KIRKLEES METROPOLITAN COUNCIL INVESTMENT & REGENERATION SERVICE

Reference No: **2023/NM/90770/E**

Site Address: Steeple View, 33 Denby Lane Crescent, Grange Moor, Huddersfield, WF4 4EB

Description: Non material amendment to previous permission 2021/92931 for erection of porch to dwelling and extension to detached garage

DRAWING TITLE
GA DRAWING - PORCH

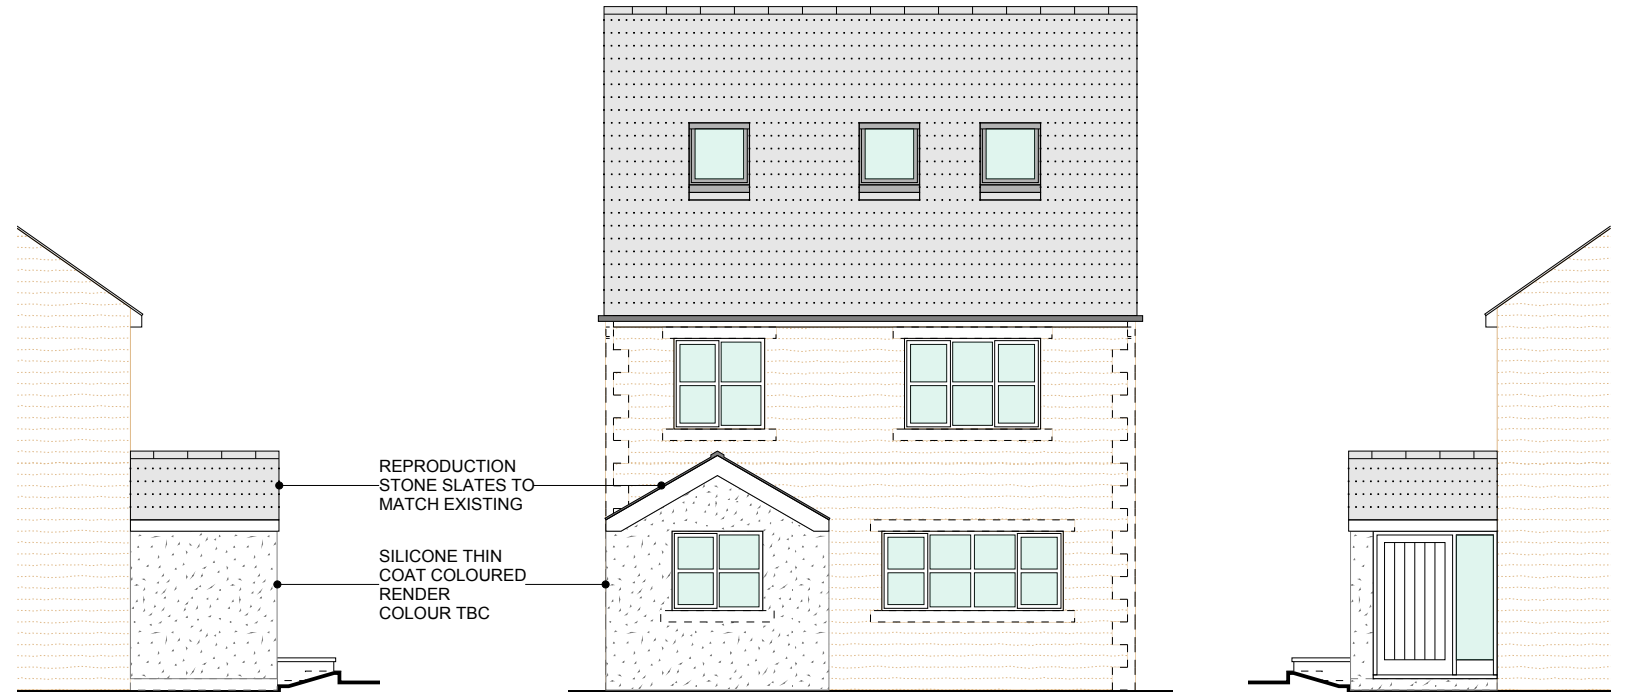
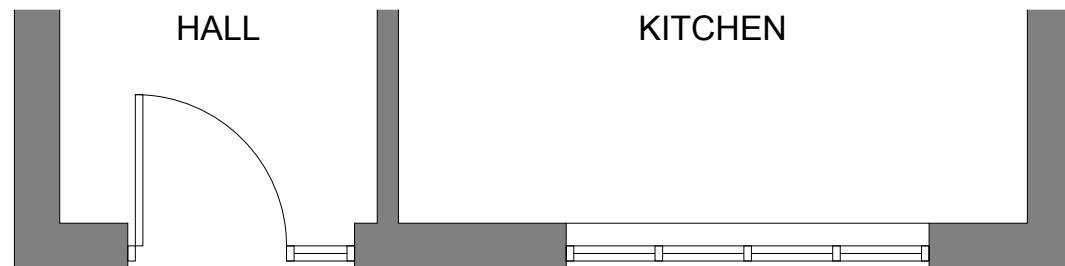
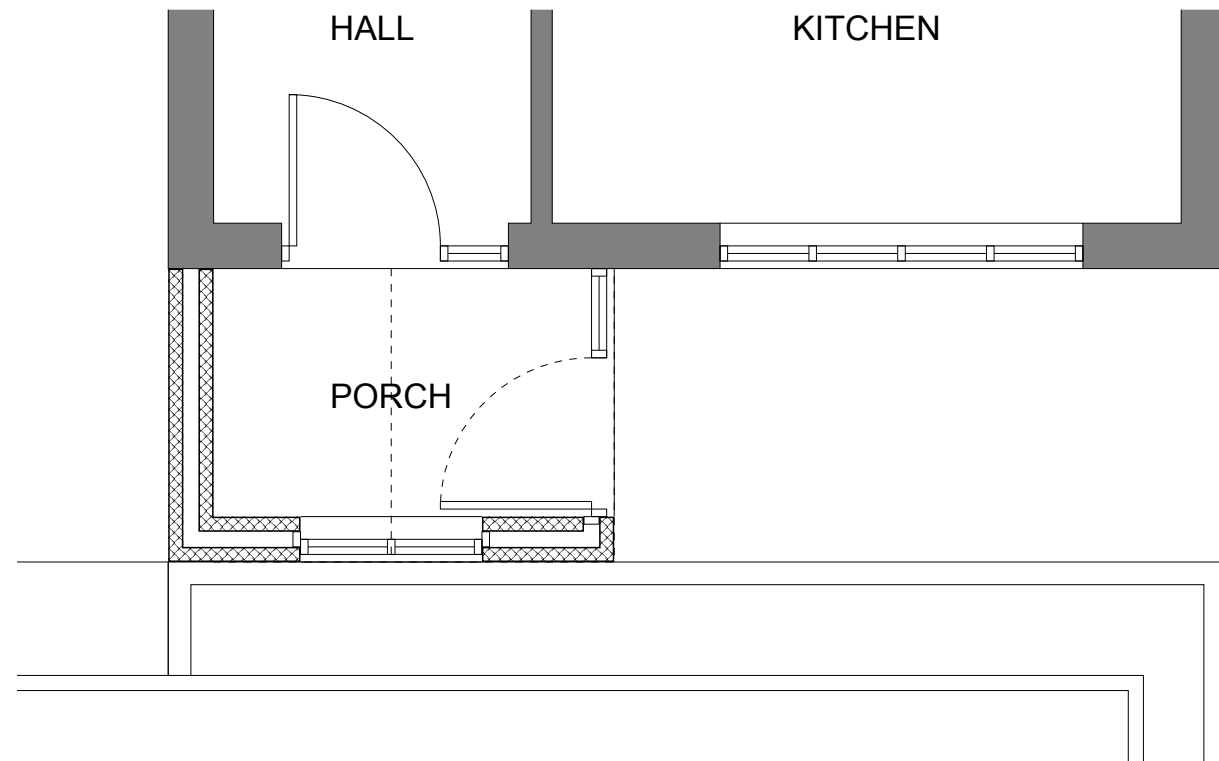
A revised porch design.

Yes, the proposed alterations to the porch would utilise the same footprint, roof design and materials. The approved porch has two open sides and a post in the corner to support the roof structure, whereas the proposed amendment would enclose the porch on all sides, with small window in the front elevation and entrance door to the south facing side elevation. The north facing side elevation would remain a solid wall with thin coat of silicone render in an off white or cream colour. This walling would be extended to the front and opposite side of the porch.

Alterations to enclose the porch on all sides, including a window in the west elevation and a front door in the south facing side elevation.

These amendments are shown on the proposed plan and elevations for the porch, drawing number 02 rev D.
